Ribble Valley Borough Council
Housing & Development Control

Your ref 3/2022/0677
Our ref D3.2022.0677
Date 5th August 2022

Application no: **3/2022/0677**

Proposal: **Proposed new tiled roof to conservatory, single storey front and side extensions to create additional living accommodation.**

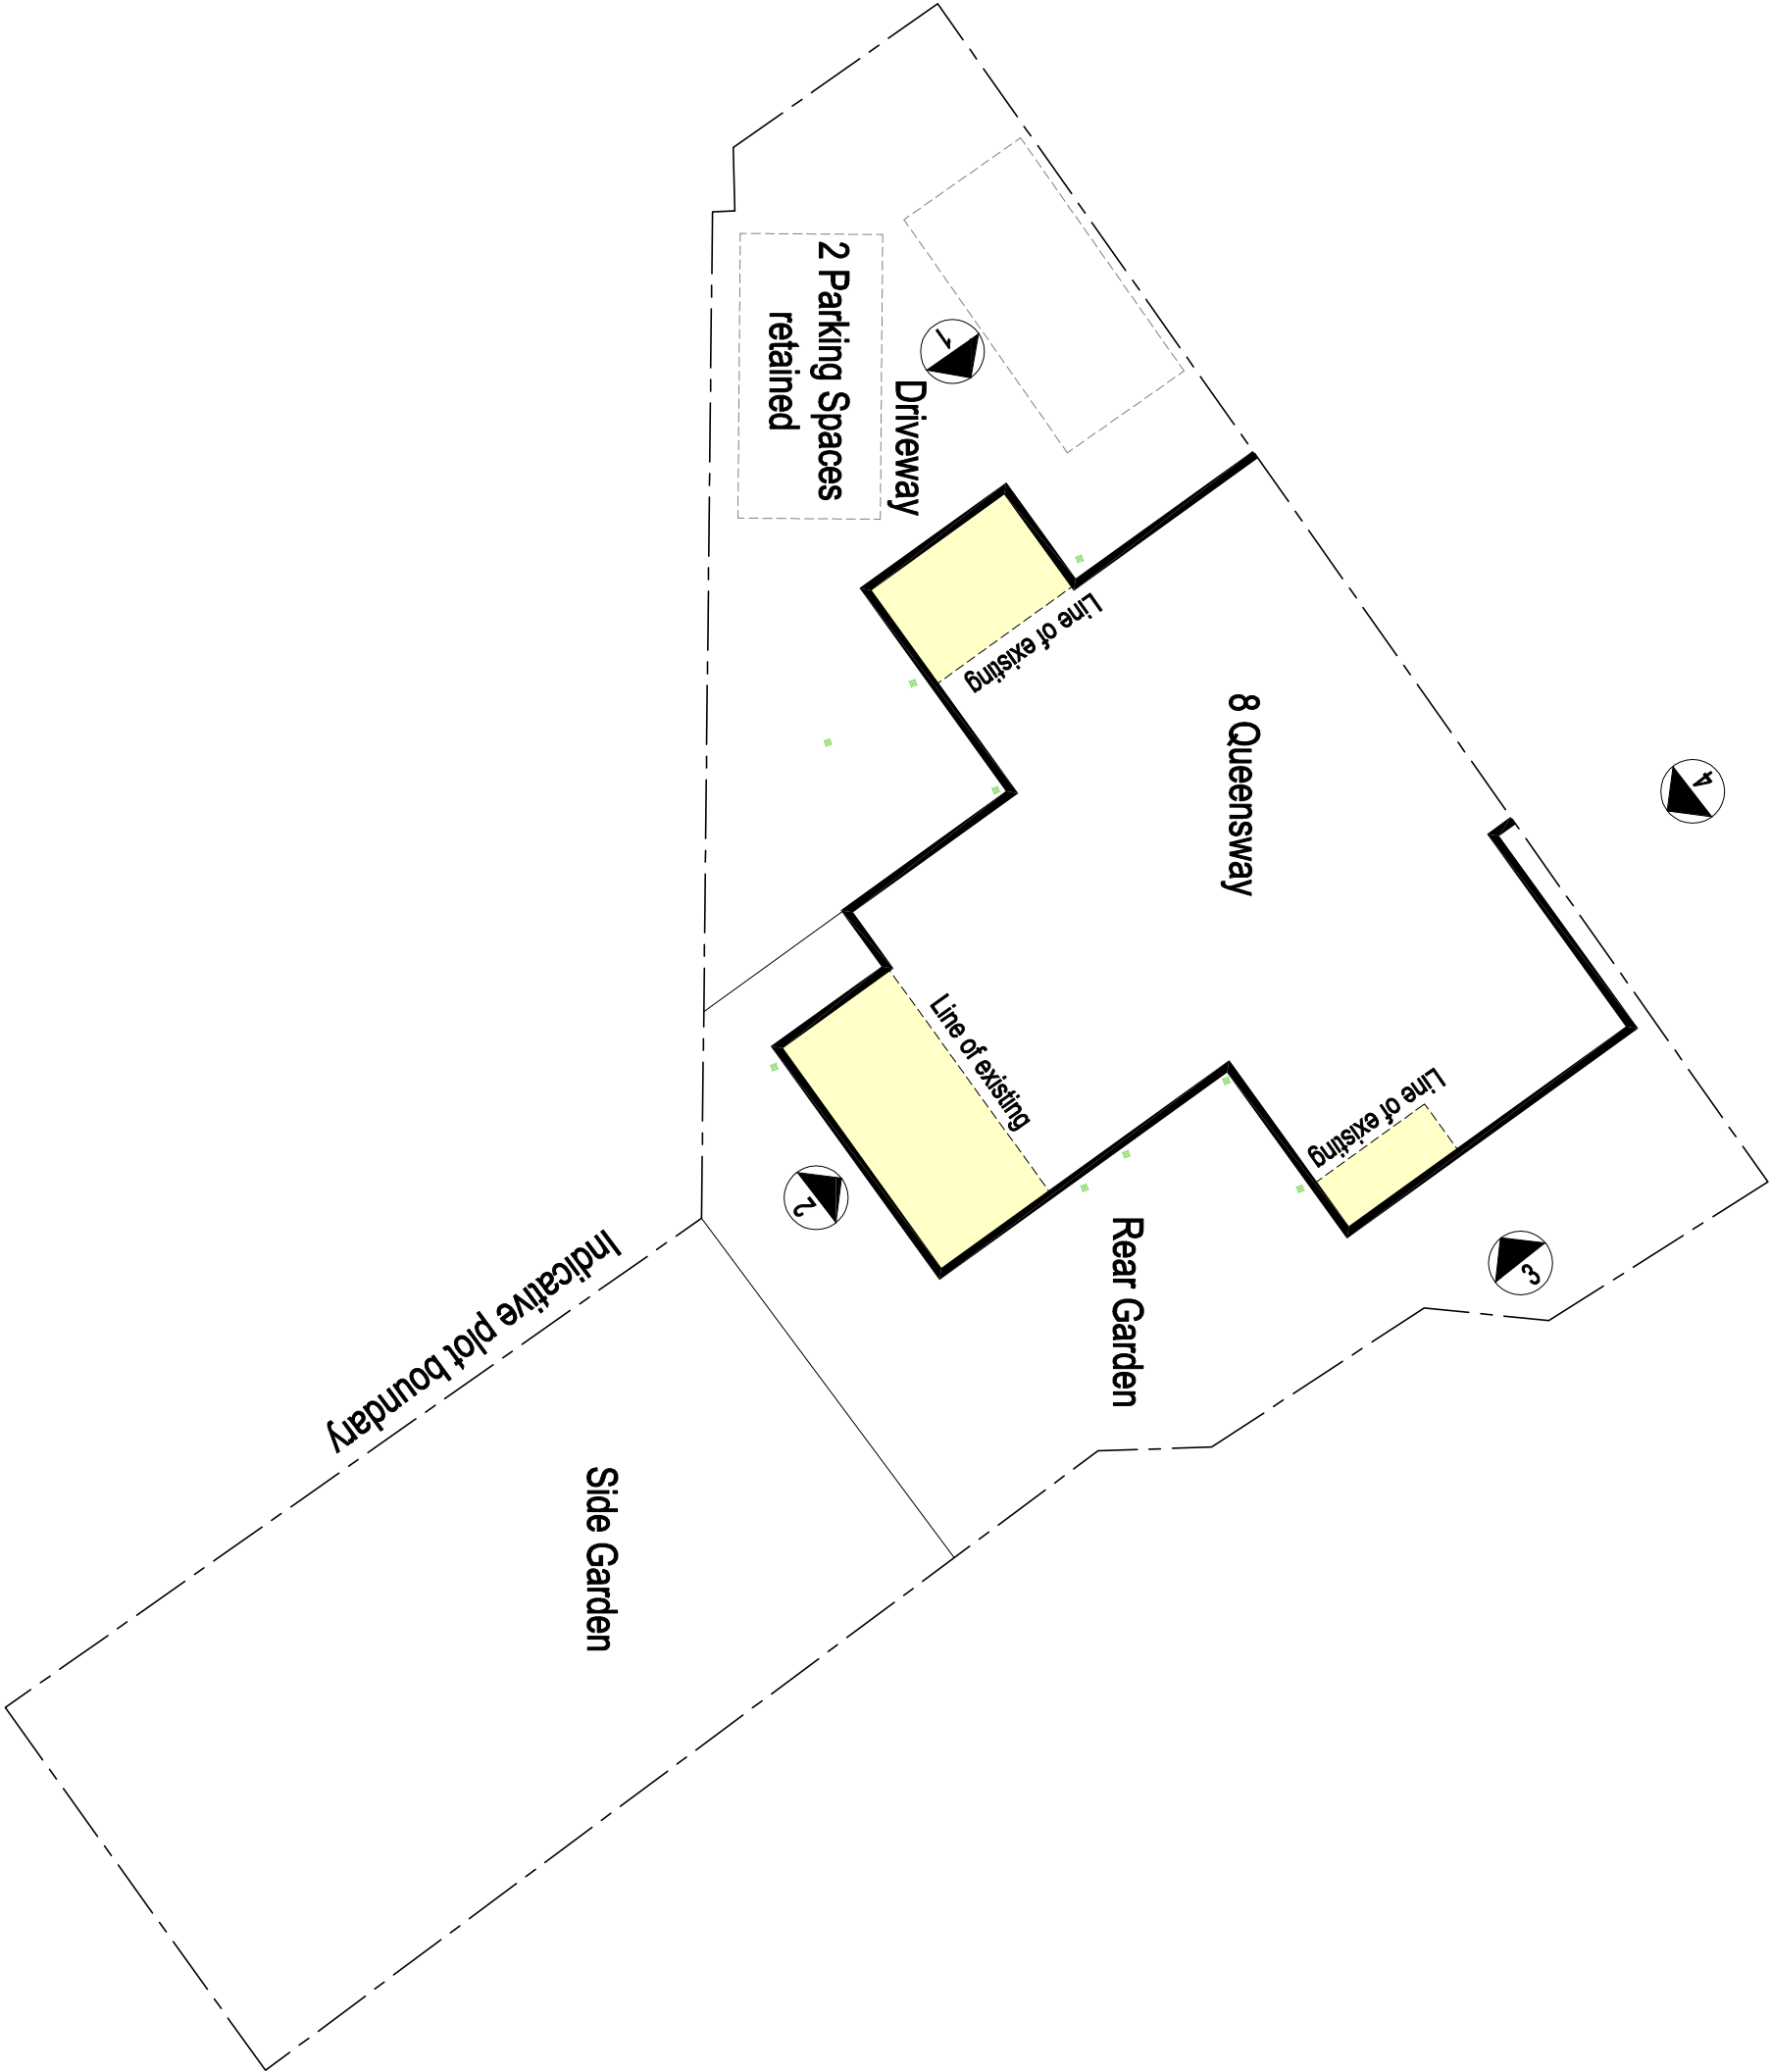
The LHA have reviewed AW+A drawing number PL/05 titled "Proposed_Site_Block Plan" and are aware that 3 car parking spaces will be provided. However, the LHA have concerns that the space located adjacent to the proposed extension will be unusable due to the proposed extension and proposed parking space being in close

proximity to each other. Usually, the LHA would require the parking space to be 2.9m wide given that it is bound by the extension. But unfortunately, there is limited space for this occur and so the LHA require the space to be removed and an amended parking plan is submitted.

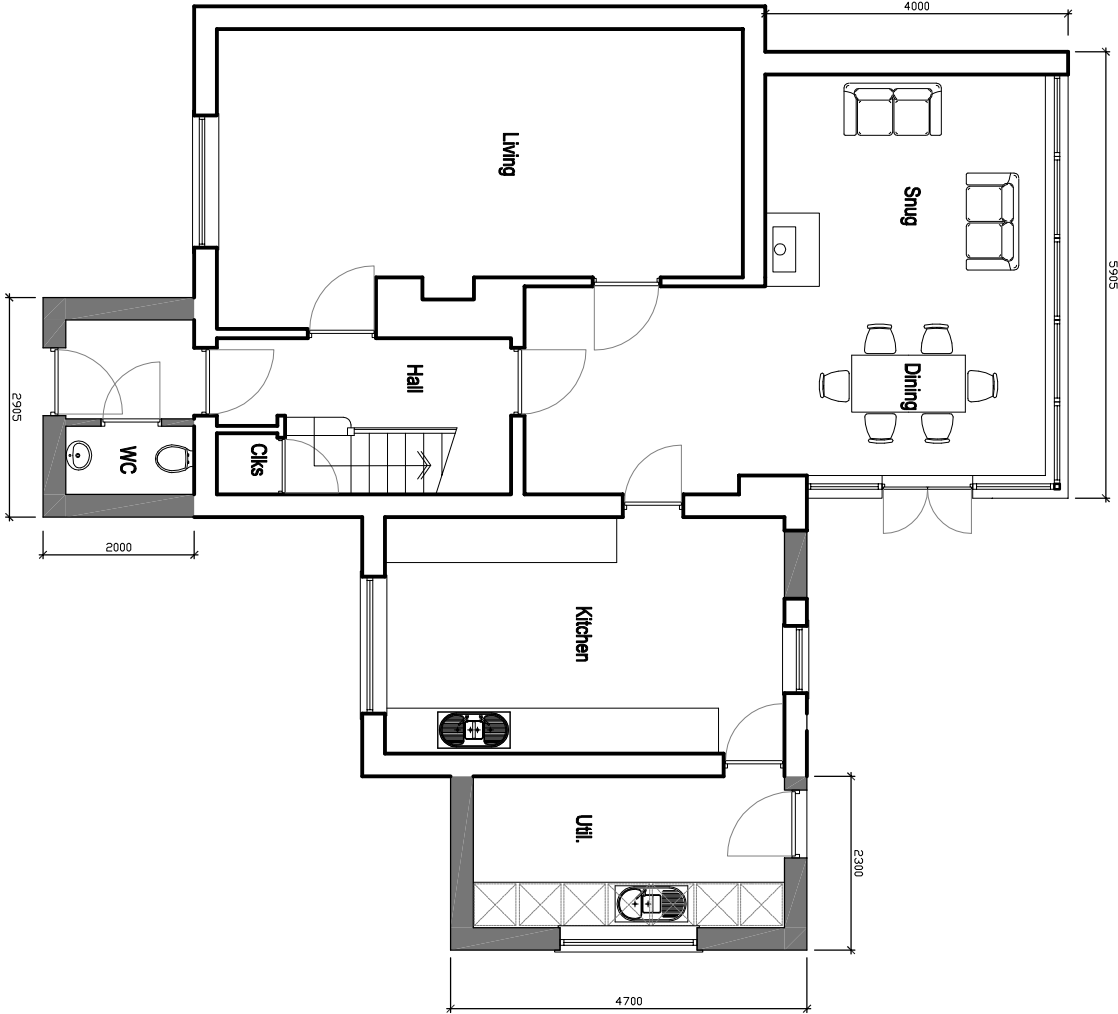
The LHA also require further information regarding how many bedrooms the dwelling will have following the proposal. The LHA remind the Agent and the Applicant that a 3-bed dwelling is required to provide 2 car parking spaces while a 4 bed is required to provide 3 car parking spaces.
